EL PASO COUNTY

DEPARTMENT OF PARKS AND COMMUNITY SERVICES

April 4, 2024

Subject: Stonebridge Metropolitan District Nos. 1-6 Review (ID-24-001)

STONEBRIDGE METROPOLITAN DISTRICT NO. 3 INFRASTRUCTURE MAP

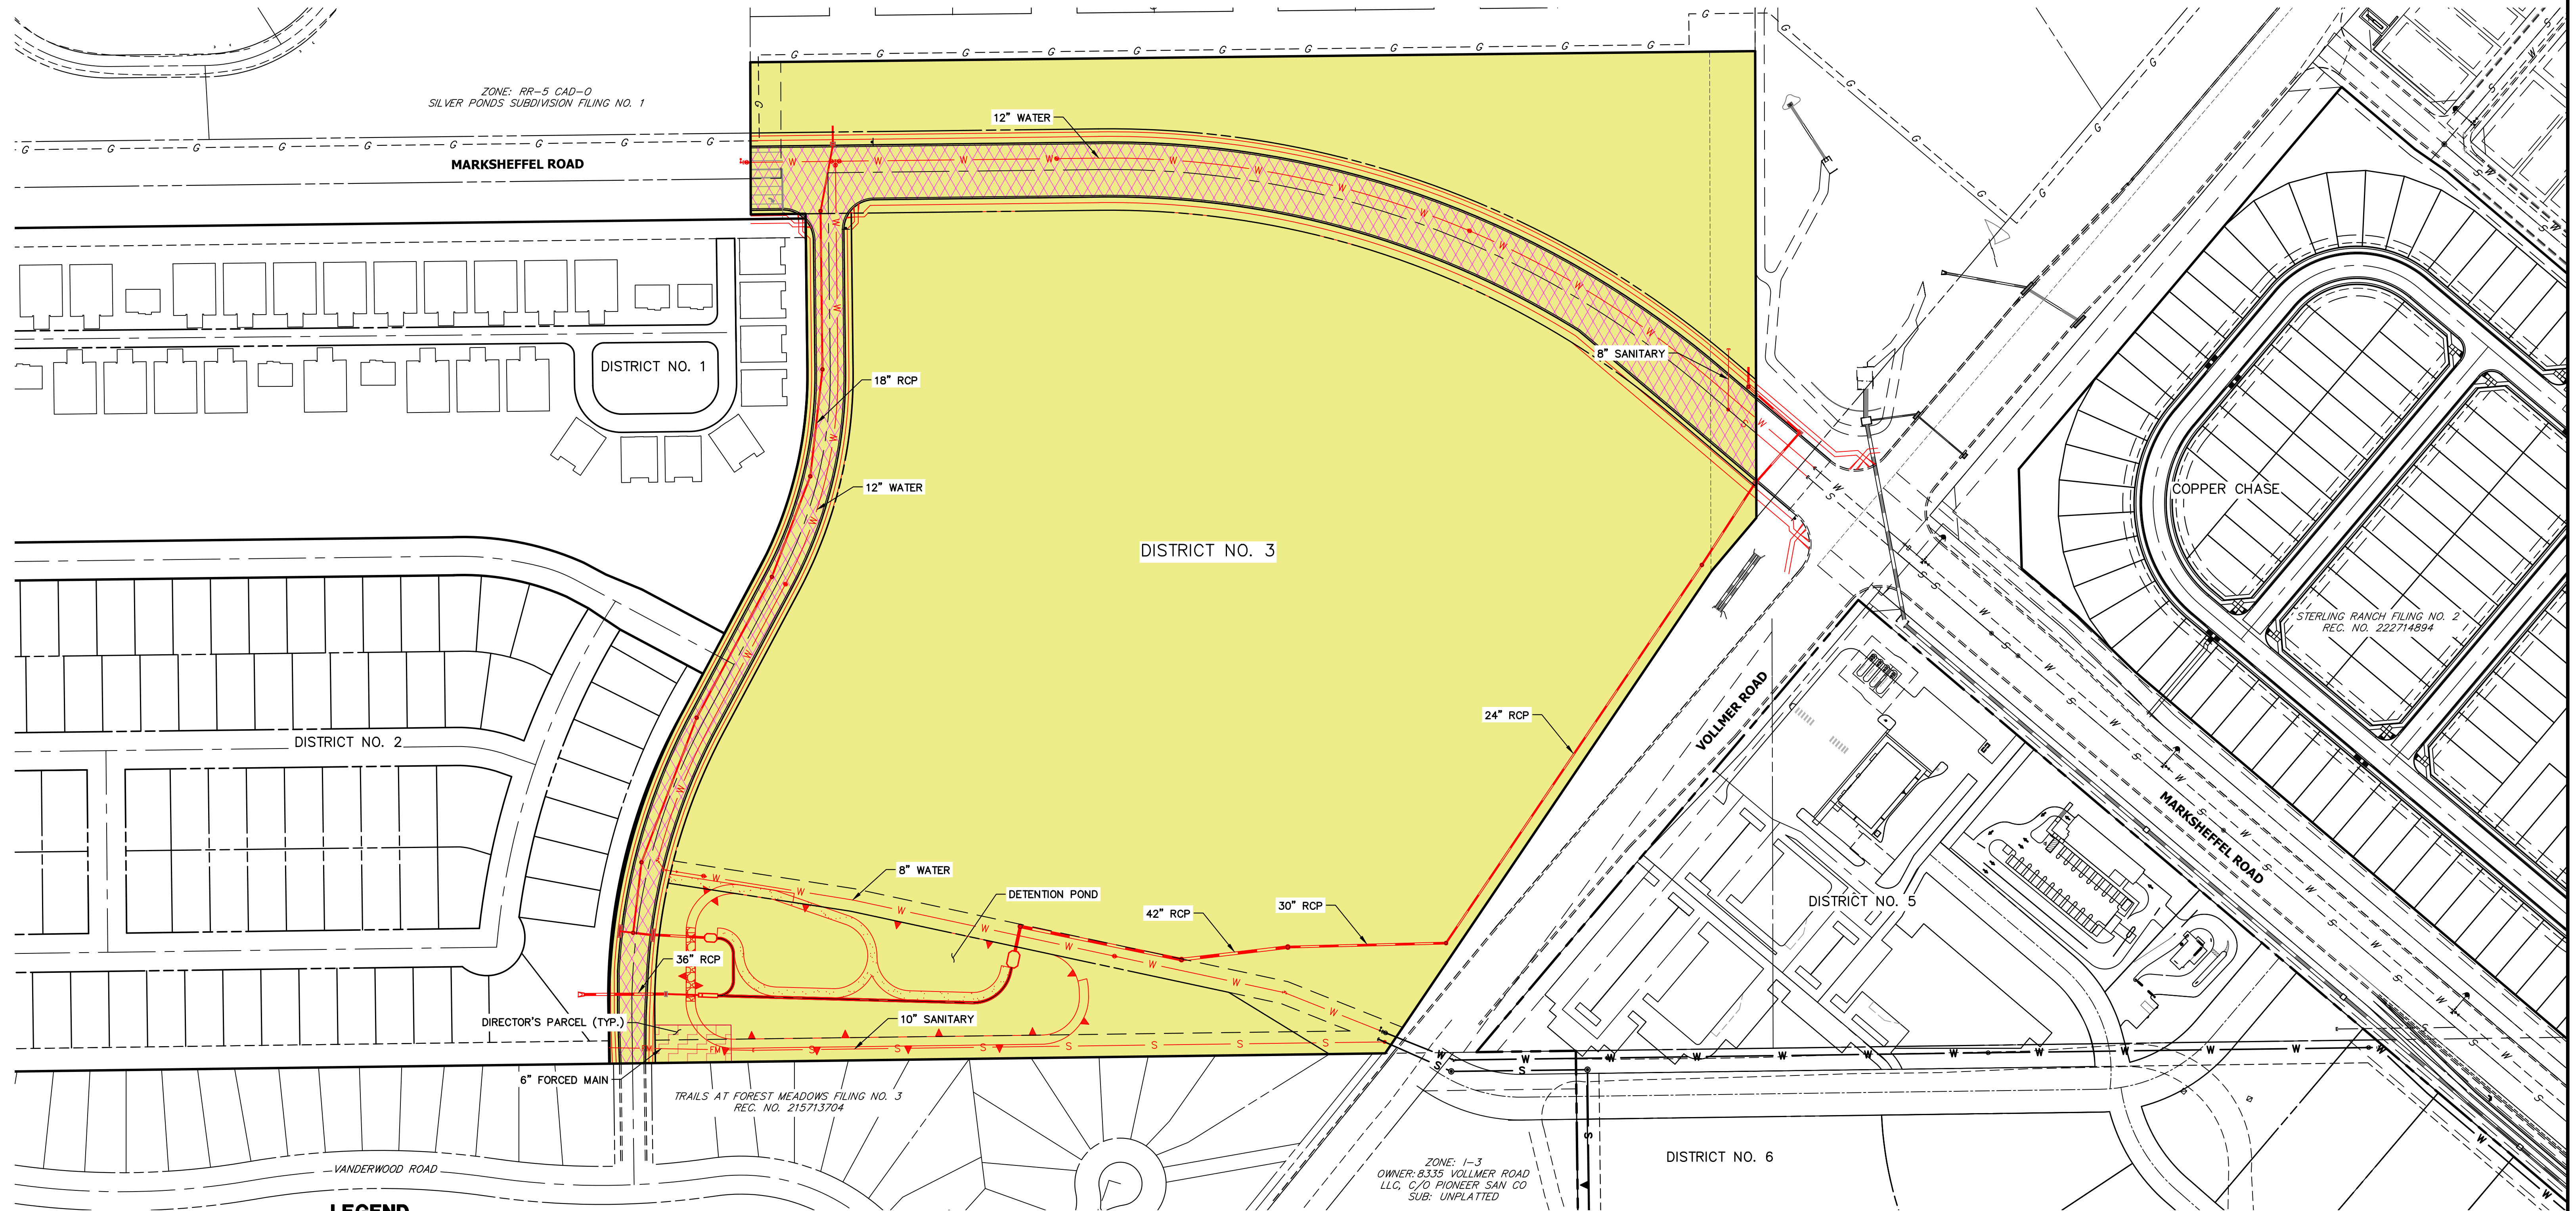
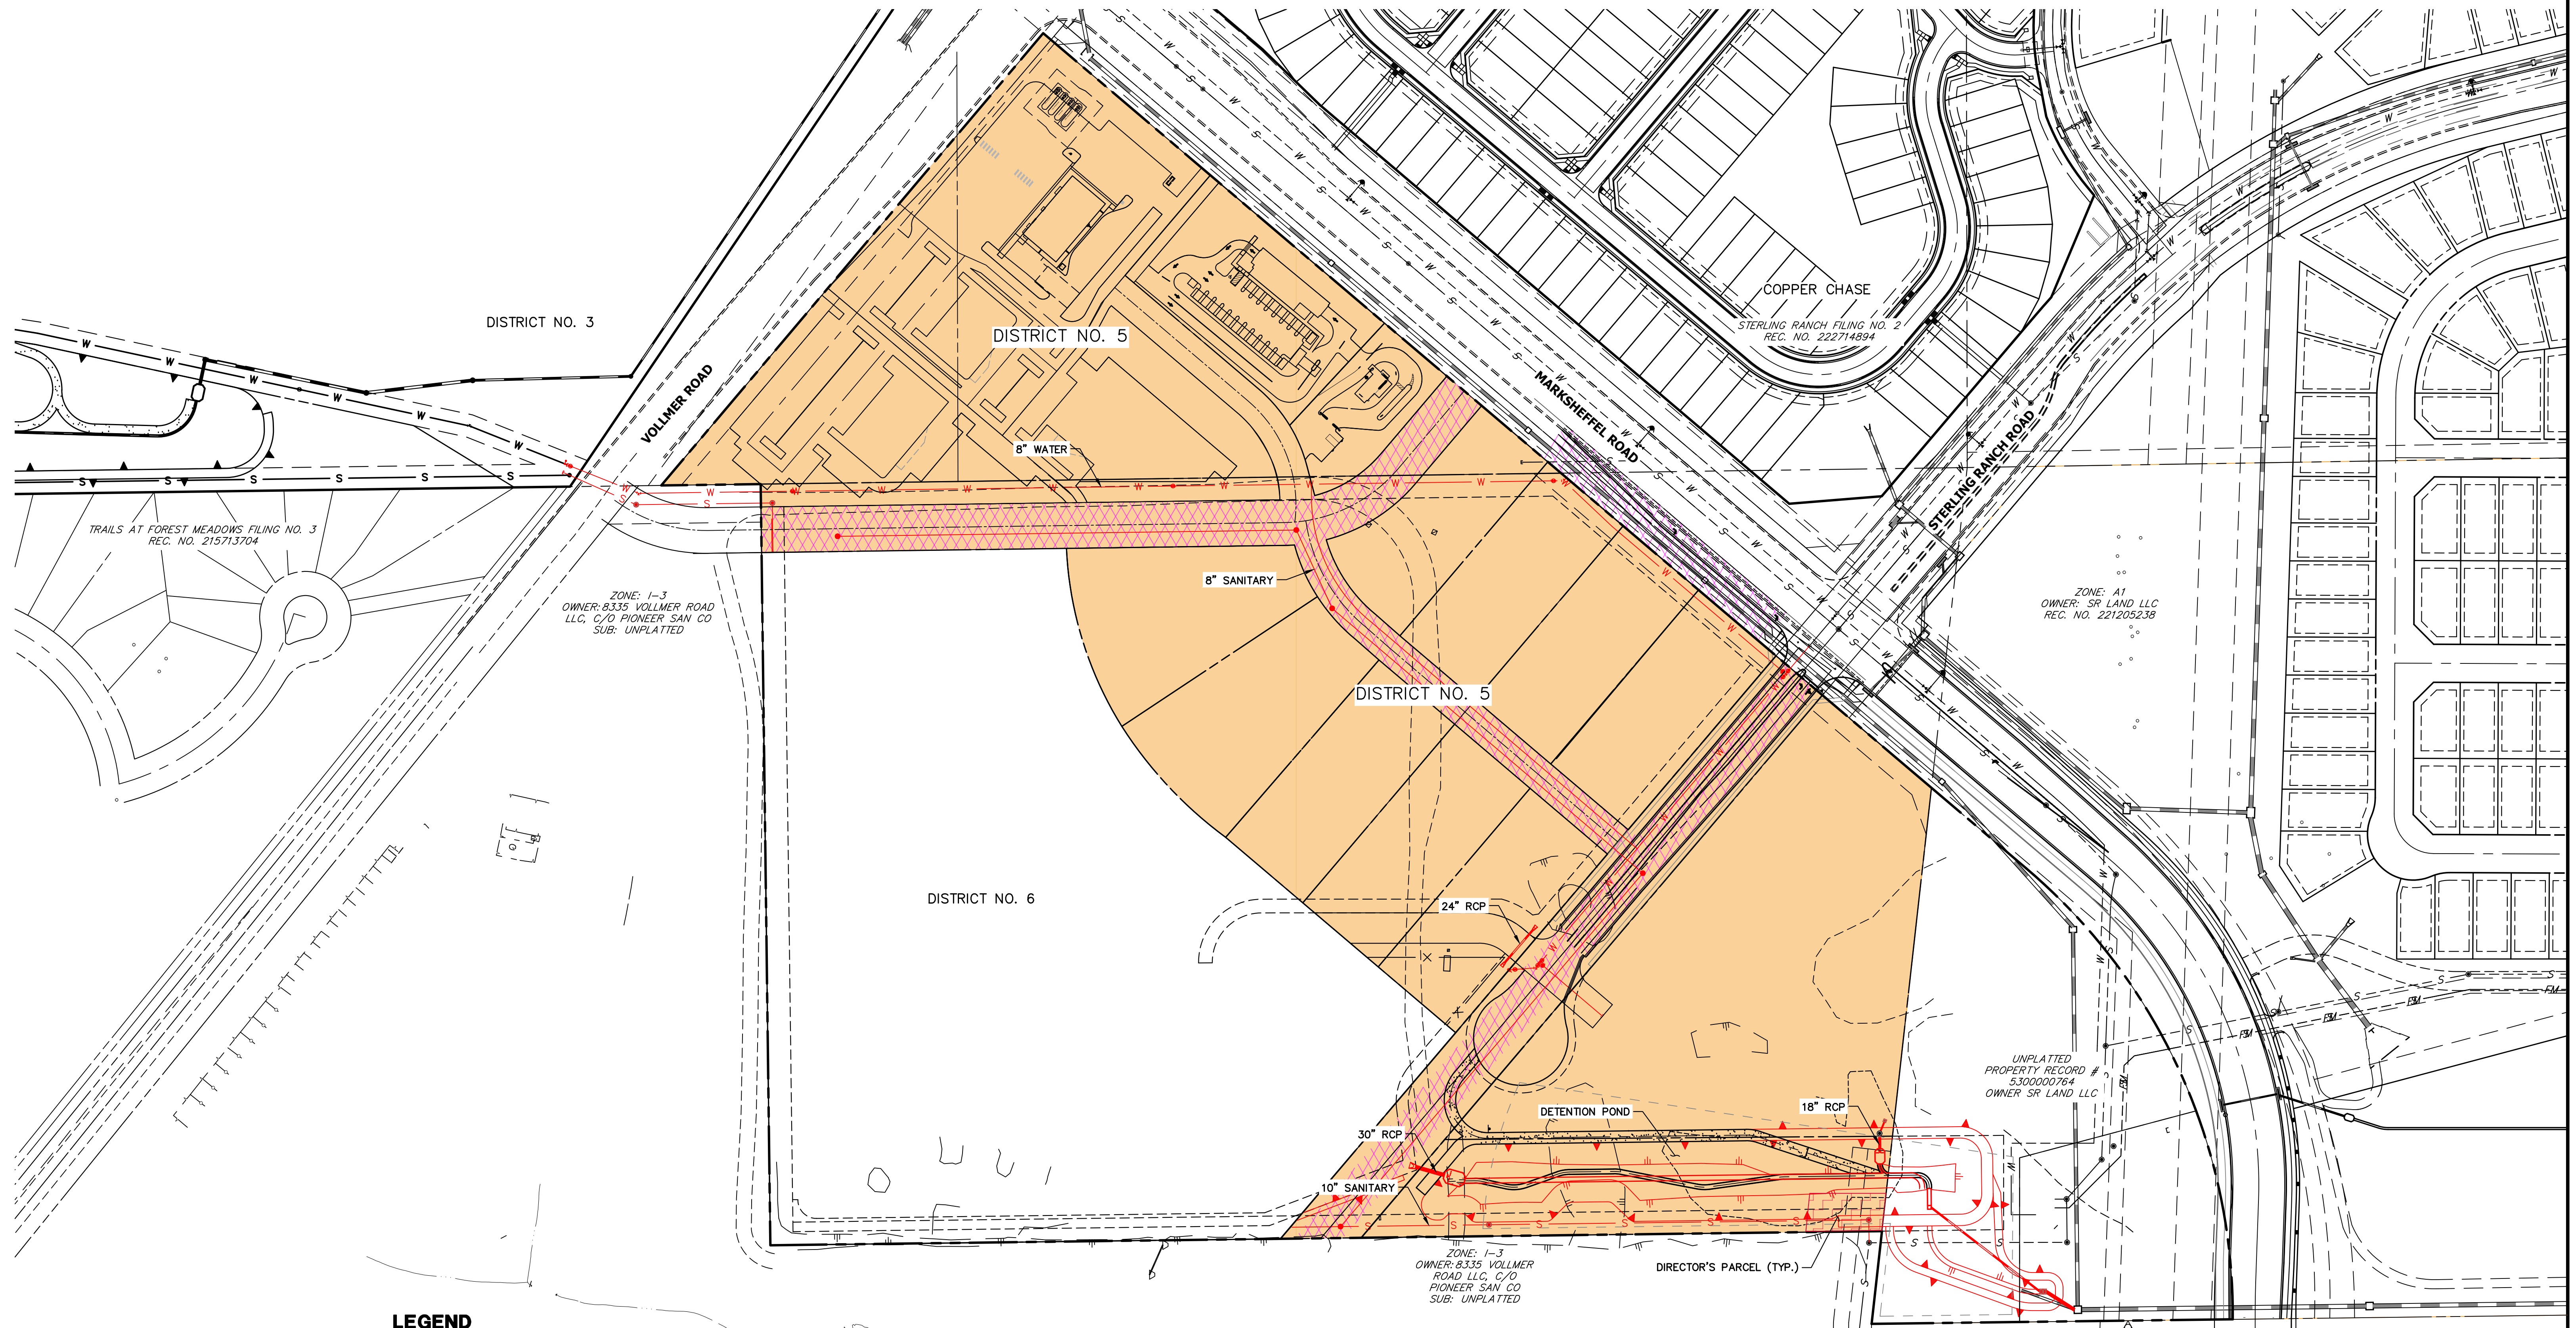
The applicant's Letter of Intent and proposed Service Plan make mention of future parks, trails, and open space, but these recreational facilities are not shown on the submitted Service Area maps. The Stonebridge Metropolitan District Service Plan and Letter of Intent do include the following statements in regard to parks, trails, and open space:

In conclusion, Parks staff is encouraged by the applicant's desire to bring high-quality recreational amenities to the residents and visitors of the Stonebridge community. However, staff recommends that the applicant include generalized plans, descriptions, and locations of these recreational facilities in either the Letter of Intent or included in the Service Area maps, as with other planned improvements, such as roadways, sewer and water deliver systems, and stormwater detention facilities.
